Your Ref: OWPC6926
Our Ref: R/221/15/HH 31-08-2015
Please ask for:
Mr D Easton

3 No. pitched roof dormer windows & porch to front elevation
5 Hawke Close Rustington

Planning application R/221/15/HH 5 Hawke Close, Rustington

SITE PLAN 1:200 @ A4 DRG Nº HC/13
5 HAWKE CLOSE RUSTINGTON BN 16 2AT

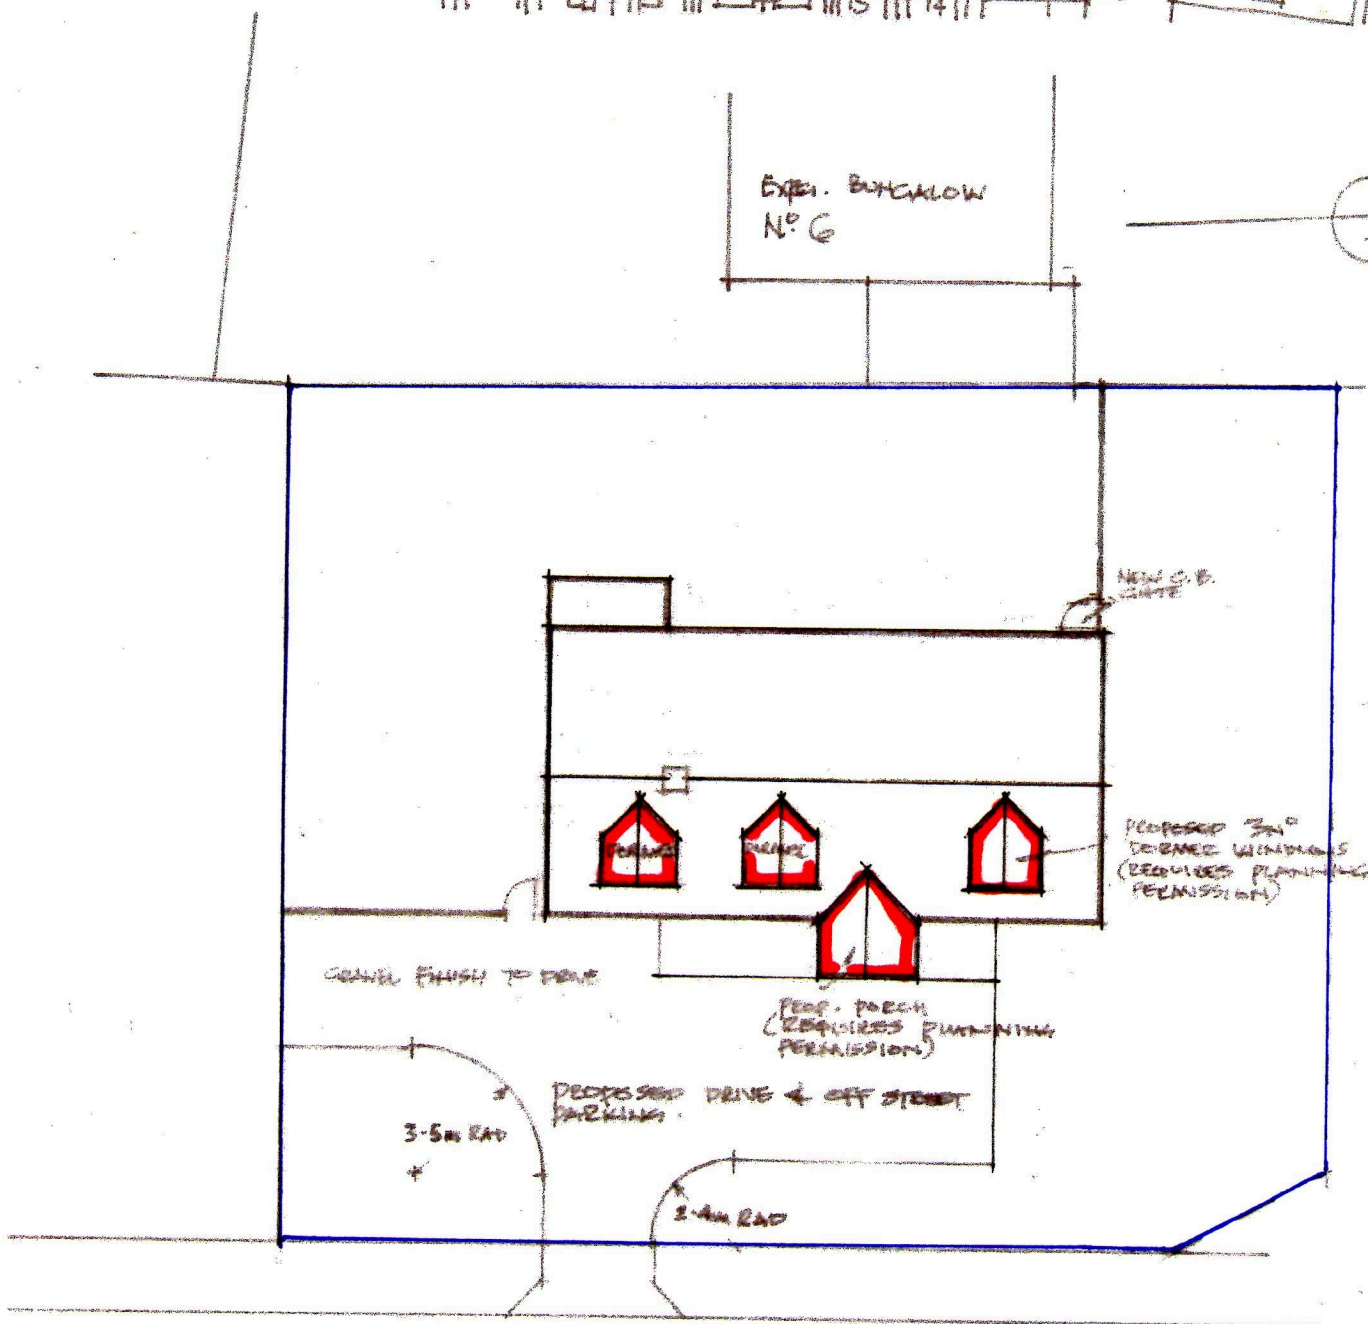
Application R/221/15/HH is incomplete in that the "floor plans" do not show the intended internal floor plans at either ground or first floor level and there is an error of fact in the representation of the boundary between No 5 and No 6 on the site plan.

DRG. NO HC/11

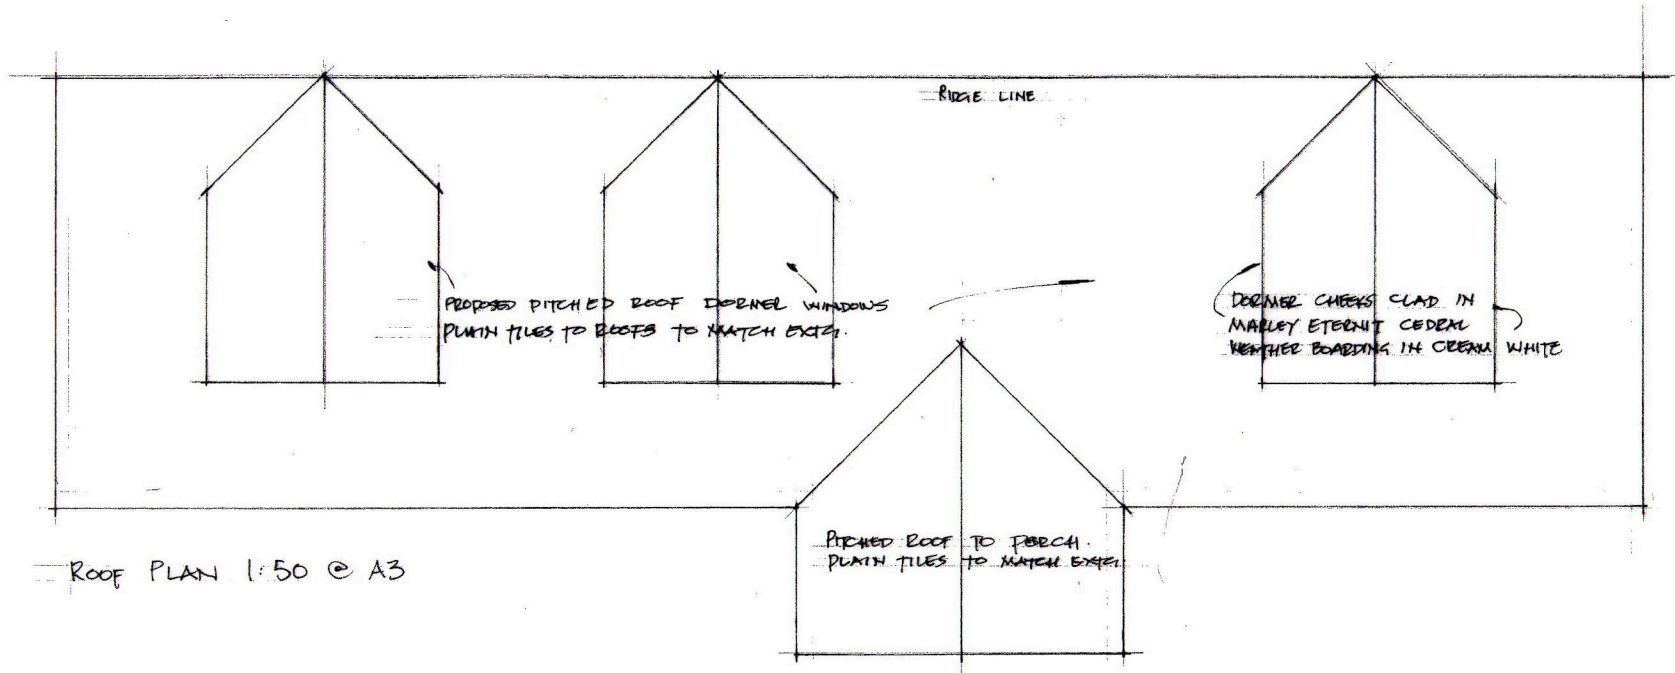
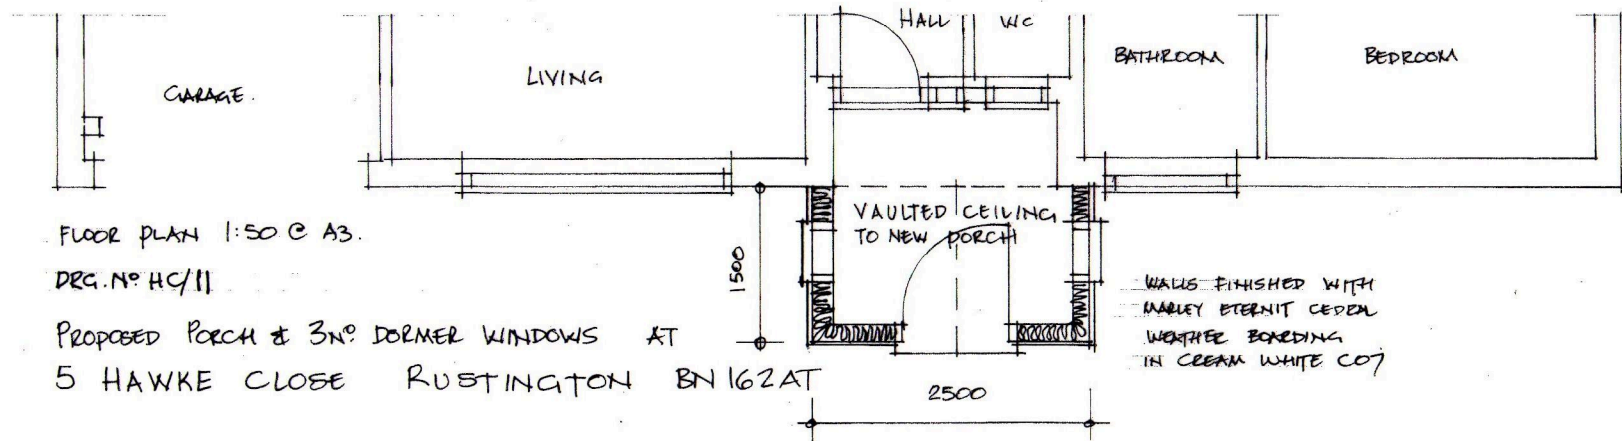
In making this Application the applicant has chosen to omit from all plans their intention to add a major first floor extension to the back of their property as is shown on their CLP application.

DRG. NO. HC/12

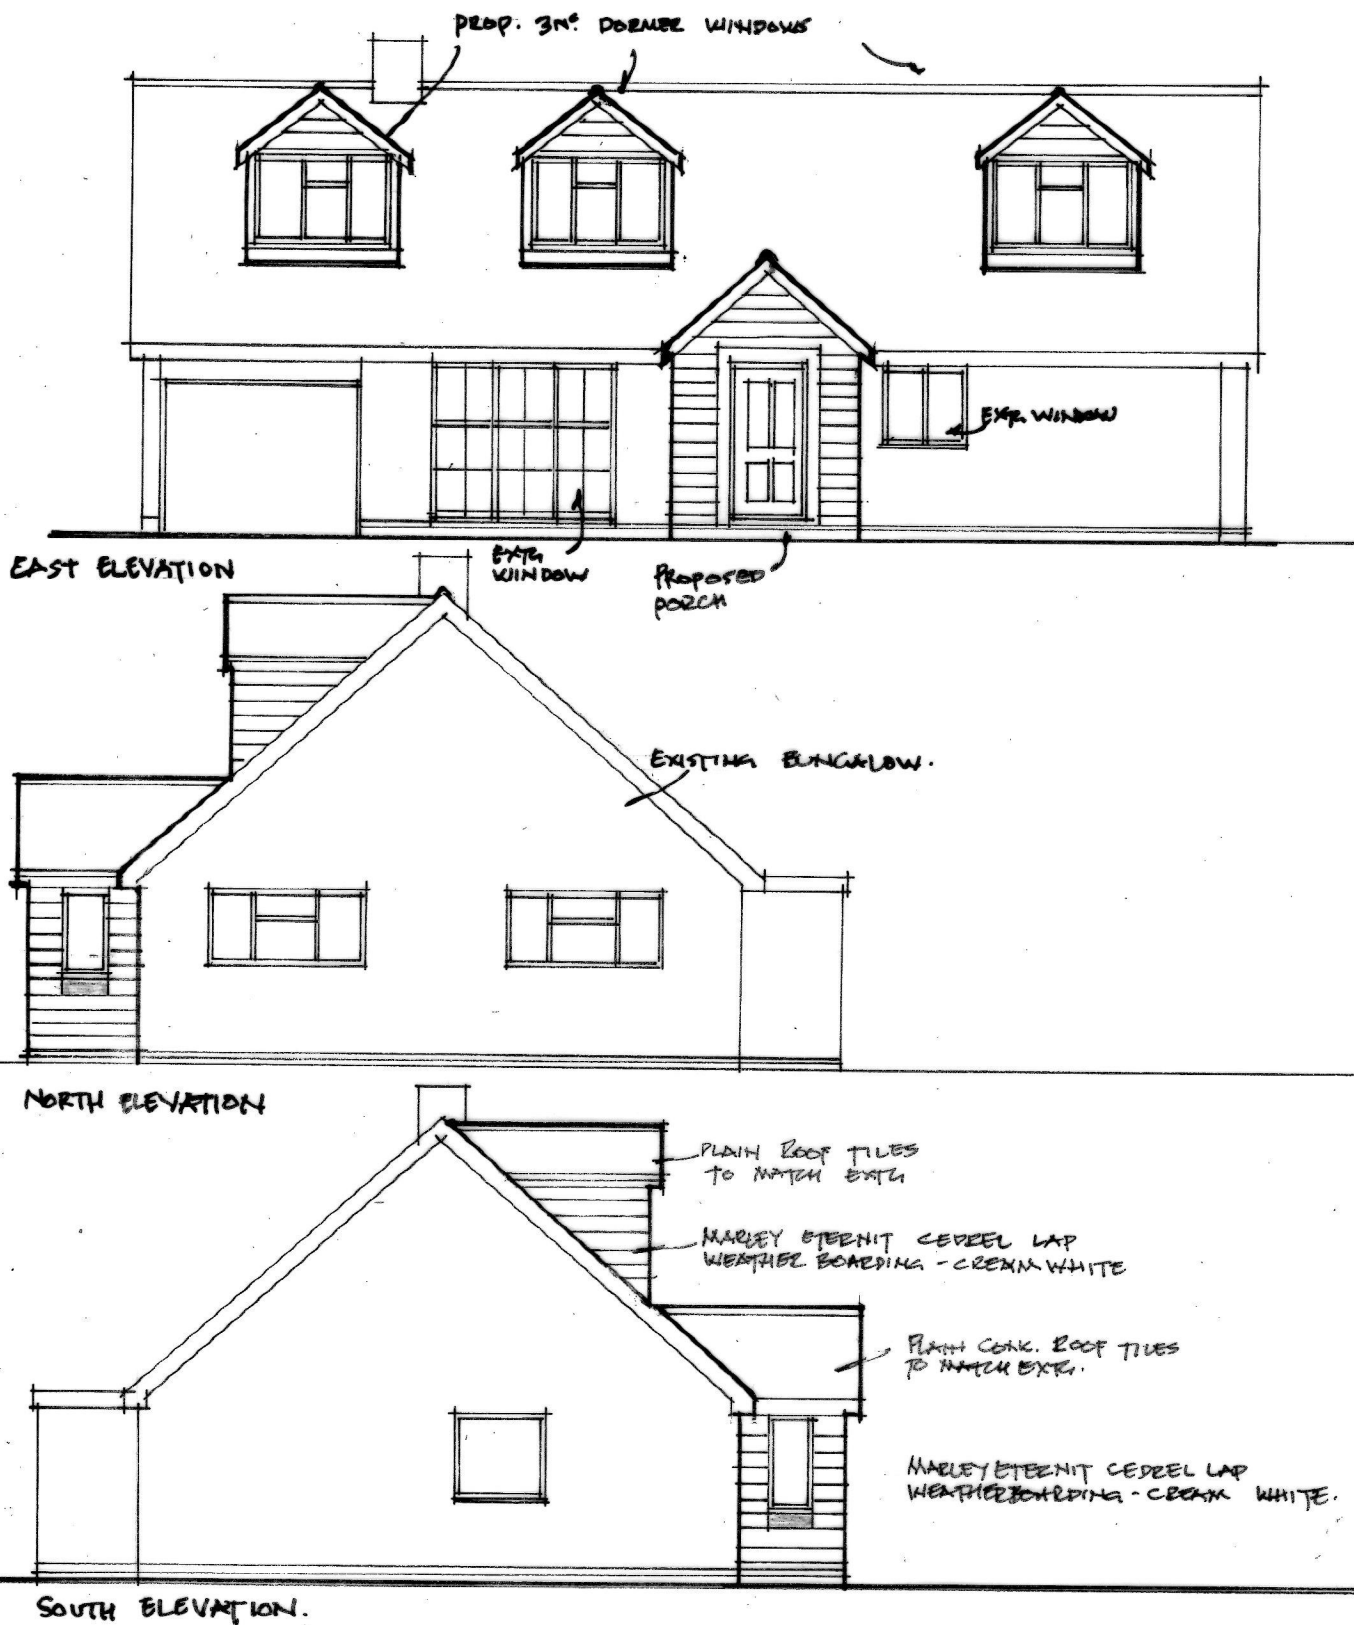
The addition of three gable windows to the front roof elevation is totally out of keeping with the rest of Hawke Close. The addition of Velux windows to No 21 Hawke Close confirms what is acceptable.

The frontages of numbers 4, 5, 33 and 34 Hawke Close are more or less in a straight line. All benefit from a recessed entrance which provides shelter and security. The addition of a porch in front of this line, as is sought in this Application must not be allowed.

ORG. N° HC/4A

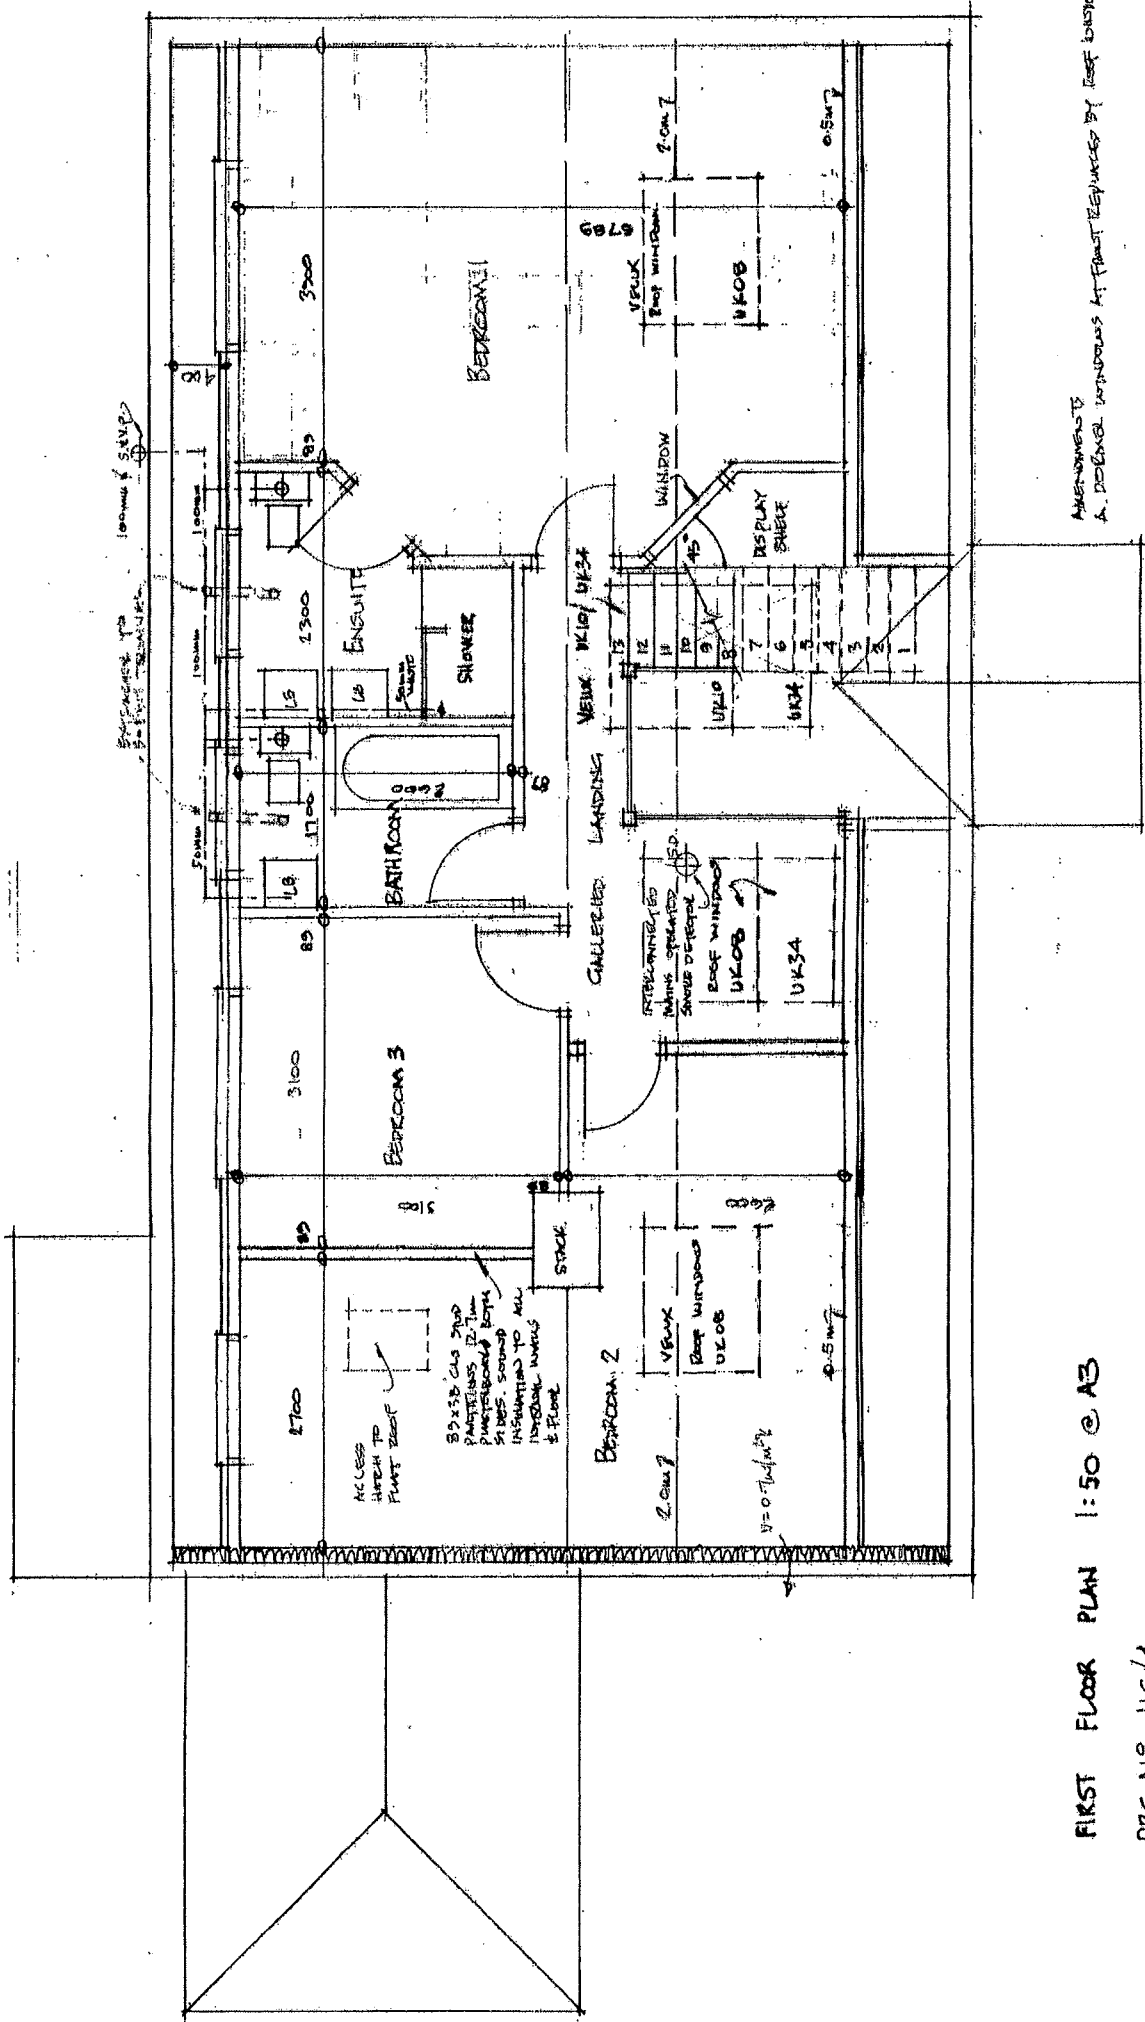
Because the main axis of No 5 is at right angles to my property the FIVE windows at first floor level on the back of No 5 will all look down on both the front and back gardens of my bungalow and directly into the East window of my sun-lounge. Should you see fit to approve this Application then I believe there is a Material Consideration relating the "Effect on privacy of existing property" that must be addressed and I should be grateful if you would add a condition that all west facing first floor windows are all glazed with obscured glass in accordance with Arun District Councils Planning Policies, including GEN7(iv).
